**EPC STORMWATER REVIEW COMMENTS  
 IN ORANGE BOXES WITH BLACK TEXT**

## EL PASO COUNTY GRADING AND EROSION CONTROL PLAN CHECKLIST

DATE: JANUARY 2024  
 JOB NUMBER: 0043.0001  
 SCALE: 1" = 10'  
 EDITION: BIDDING  
 SHEET: C9 OF C31

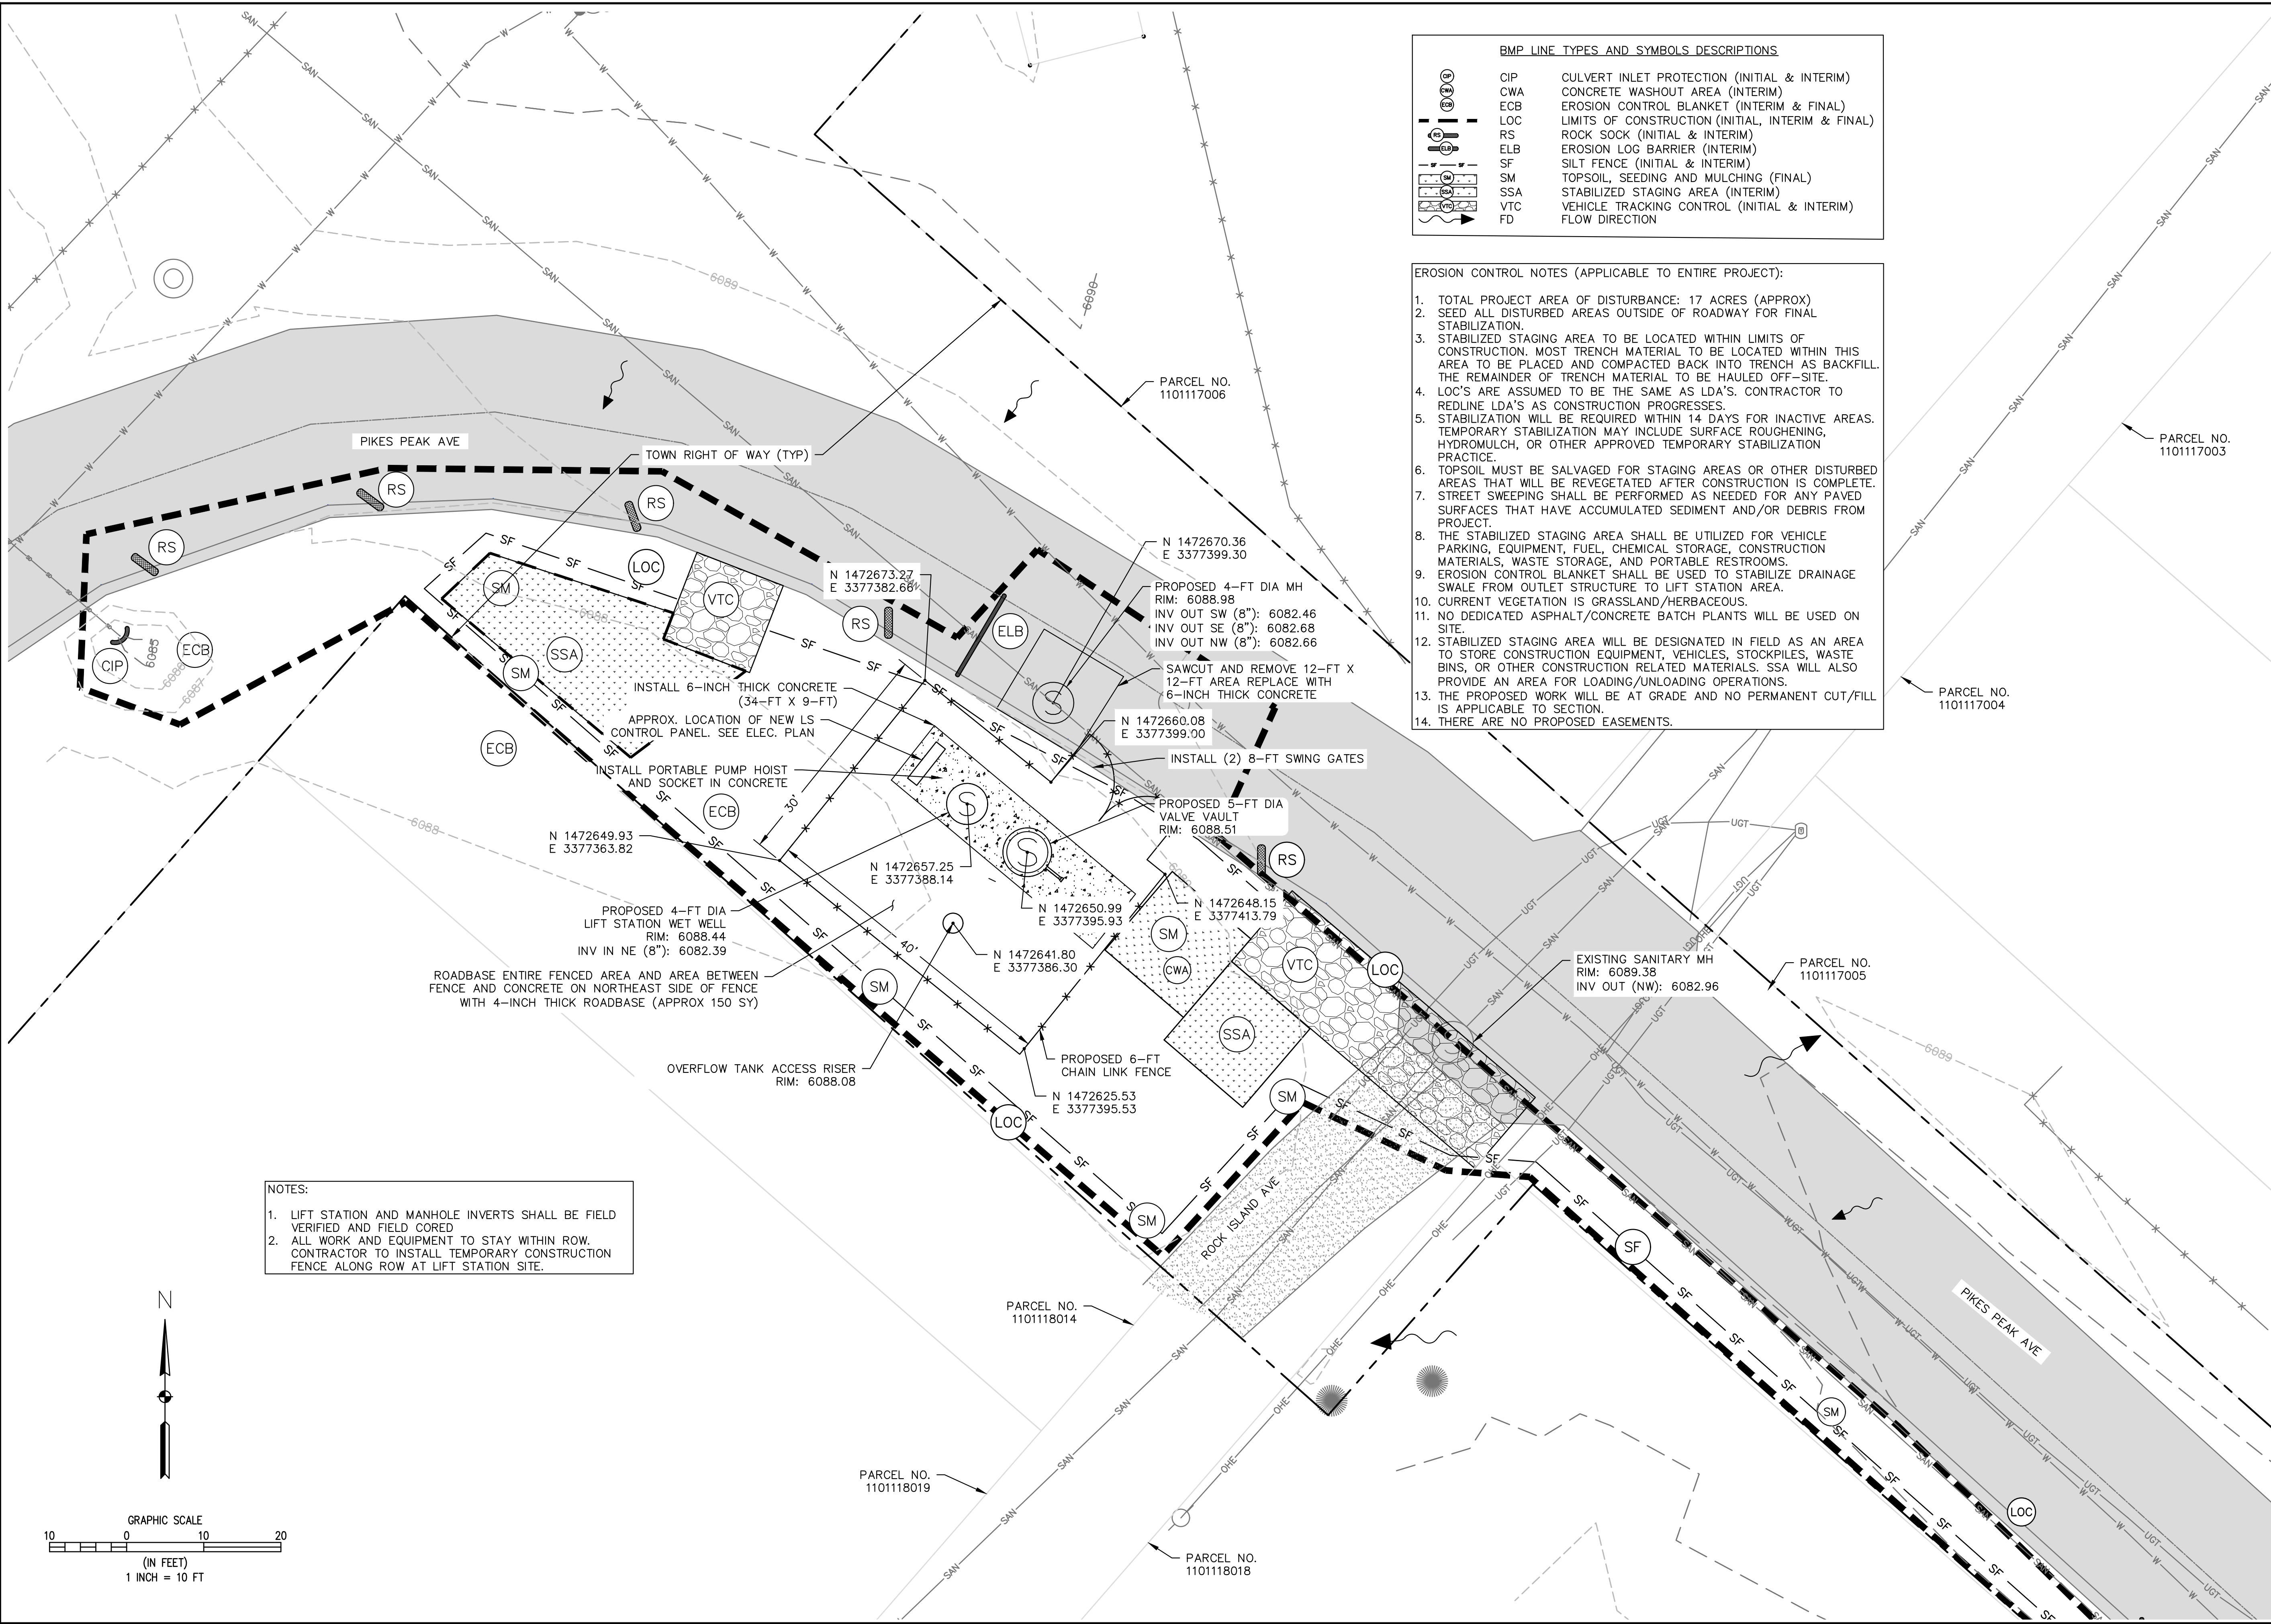
The plans do not show an off-site control measure the site is draining to. Either clearly show on plans and discuss in drainage report or put N/A
